From: Amanda Scholes on behalf of Planning.Responses
Sent: 30 November 2020 10:24
To: Planning Scanning
Subject: FW: M/68/20/PL Poultry Farm, Middleton

Subject: M/68/20/PL Poultry Farm, Middleton

The above application was taken to Member Briefing Panel today. Can you please confirm the following details prior to next Wednesday?

SCALE: 200@A3
DATE: MAY 20
AUTHOR: -
DRG. NO: 2017/PA/022
FILE:

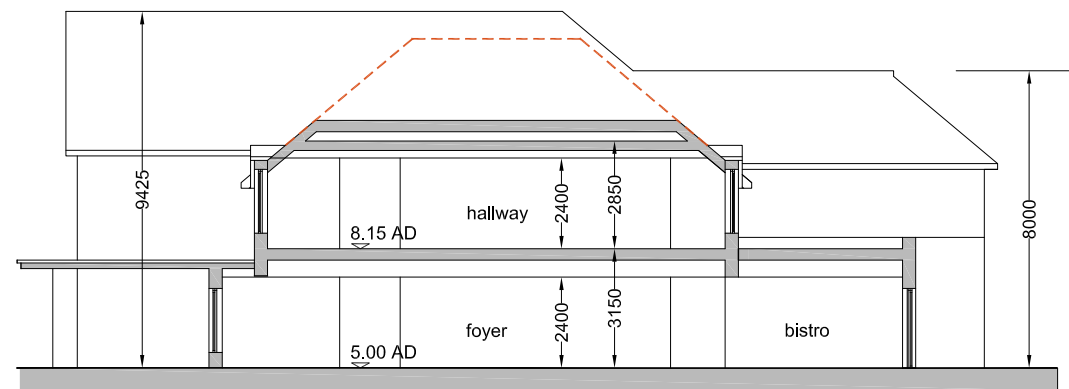
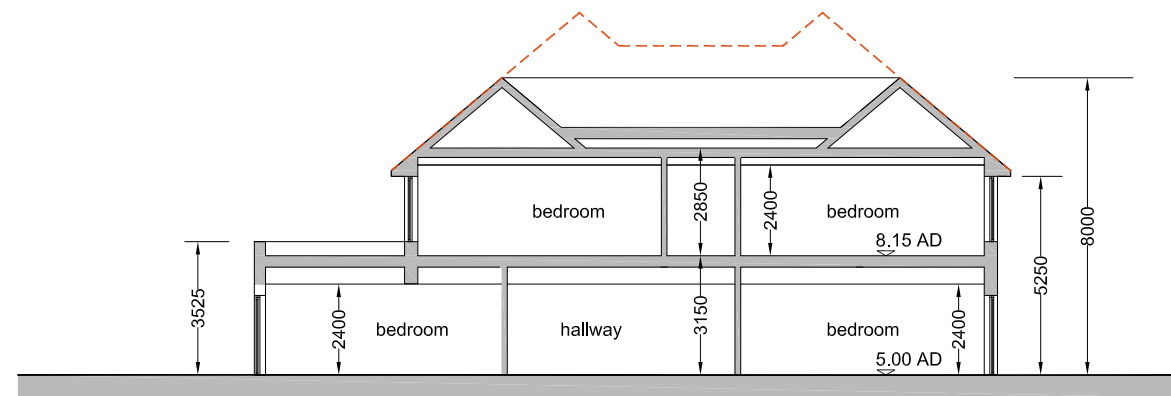
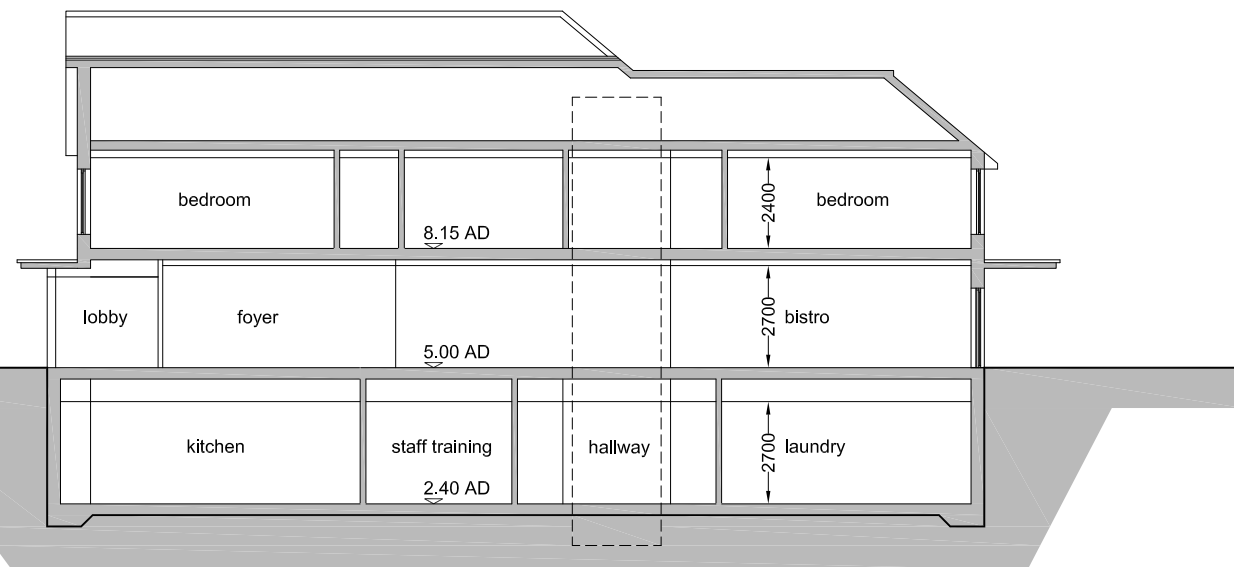
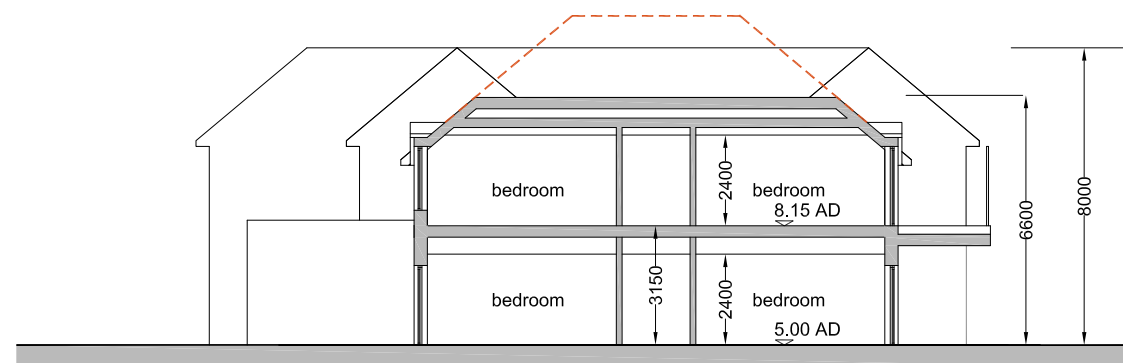
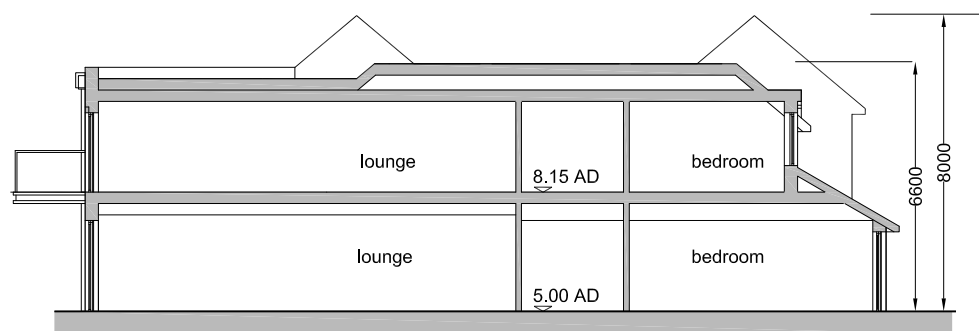
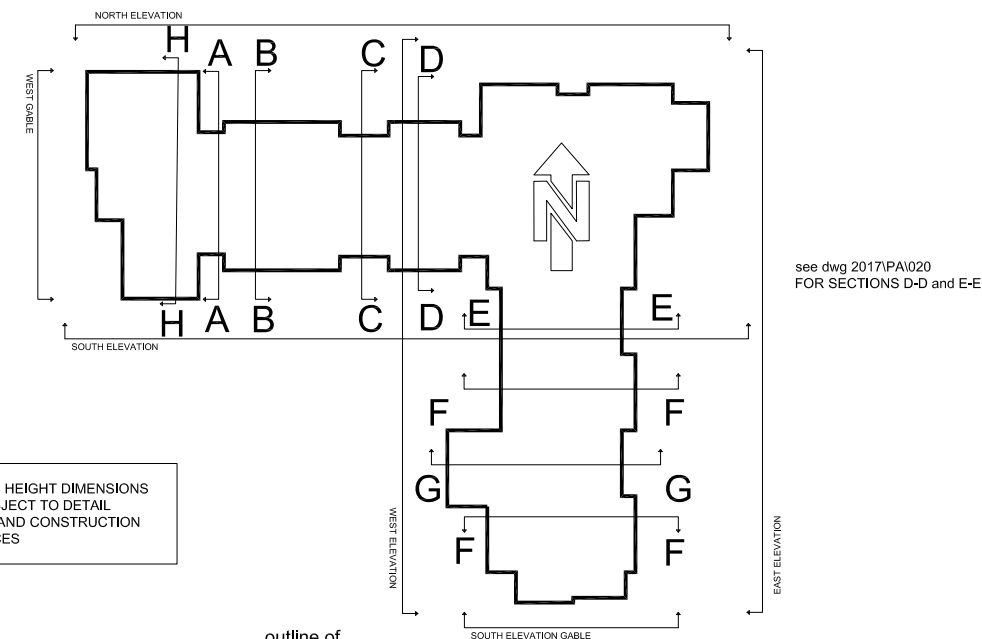
Is the development being dug into the site to reduce the height?

How will air from the basement area be extracted? There is concern that the amenity in this area is poor for people utilising it.

- The ground floor level is the same as the previous scheme -- it is not dug into the site.

- The height is reduced only by lowering roof ridge lines.
- The basement is served by extract air and make up air via risers to air handling plant in the empty roof void above.
- Air in will be tempered for temperature control. Additional cassette "a/c" units will be provided in the staff lounge and laundry.
- Air out will be filtered from laundry and kitchen extracts and expelled via acoustically baffled roof vent cowls.
